5 November 2012

Director - Infrastructure Projects
Epping to Thornleigh Third Track Project – SSI 5132
New South Wales Department
Of Planning & Infrastructure
GPO Box 39
SYDNEY NSW 2001

EPPING TO THORNLEIGH THIRD TRACK PROJECT – SSI 5132

Figure 5.6 Cross-section and elevation - New Cheltenham Station concourse building
Note: Indicatively added to future design

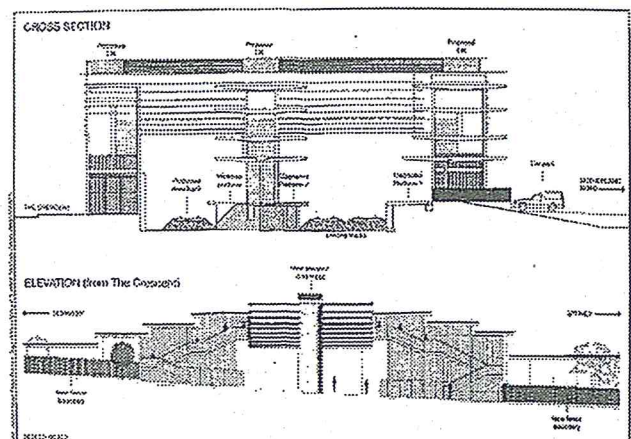
The visual impact of a two storey concourse is significant and unfortunately the EIS only addresses this in relation to heritage items thus avoiding the impact on other people and the outlook from their front yards and windows.

Proposed changes at Cheltenham Station - 54 The Crescent indicated by pink shading and arrow.

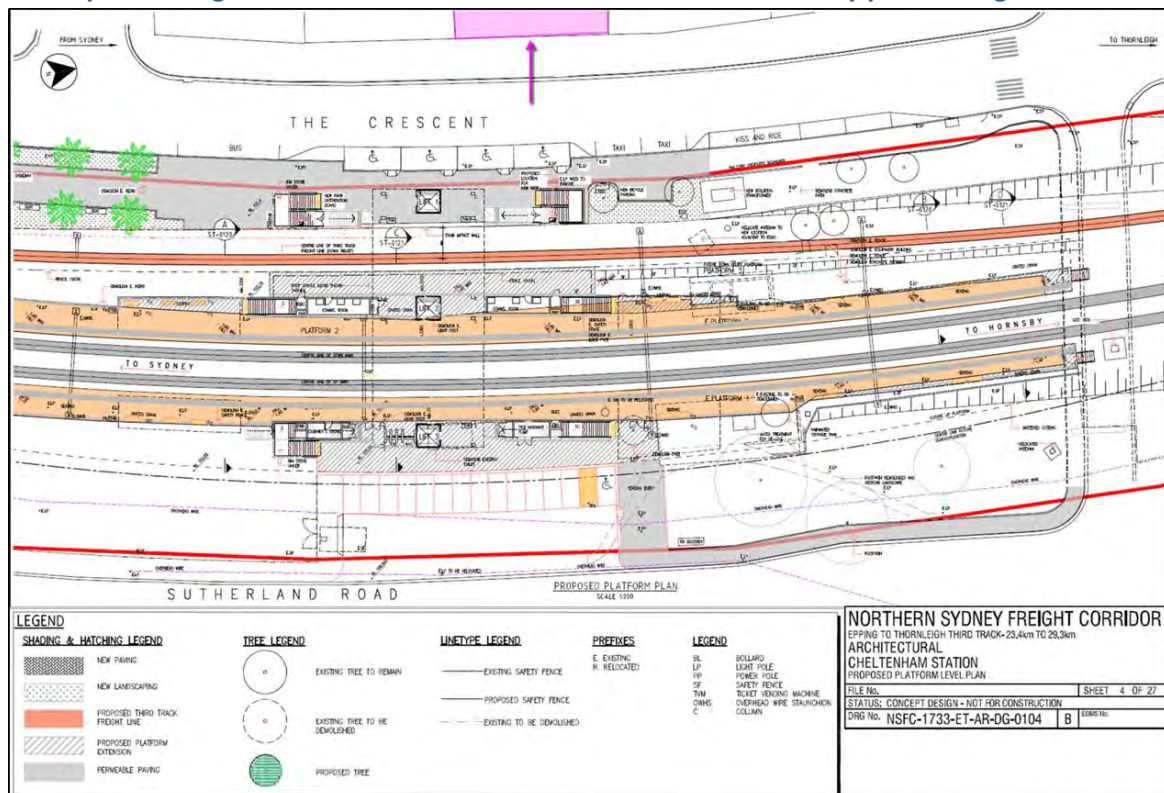
Page 242 states we are 15m from the proposed area of impact and we **may** be impacted by a new car park a two storey station concourse and the removal of trees from the Crescent. It makes no comment on the impact of a new train line realigned 20m closer to our house.

Page 244 states that it is possible that the works will have a negative impact on the views and setting of the house. The report goes on to say (in the writer's opinion) that there will be a negative impact of views from the house, but it would impact on the overall heritage value of the item. No mention of the impact of the loss of utility as it is a heritage only report.
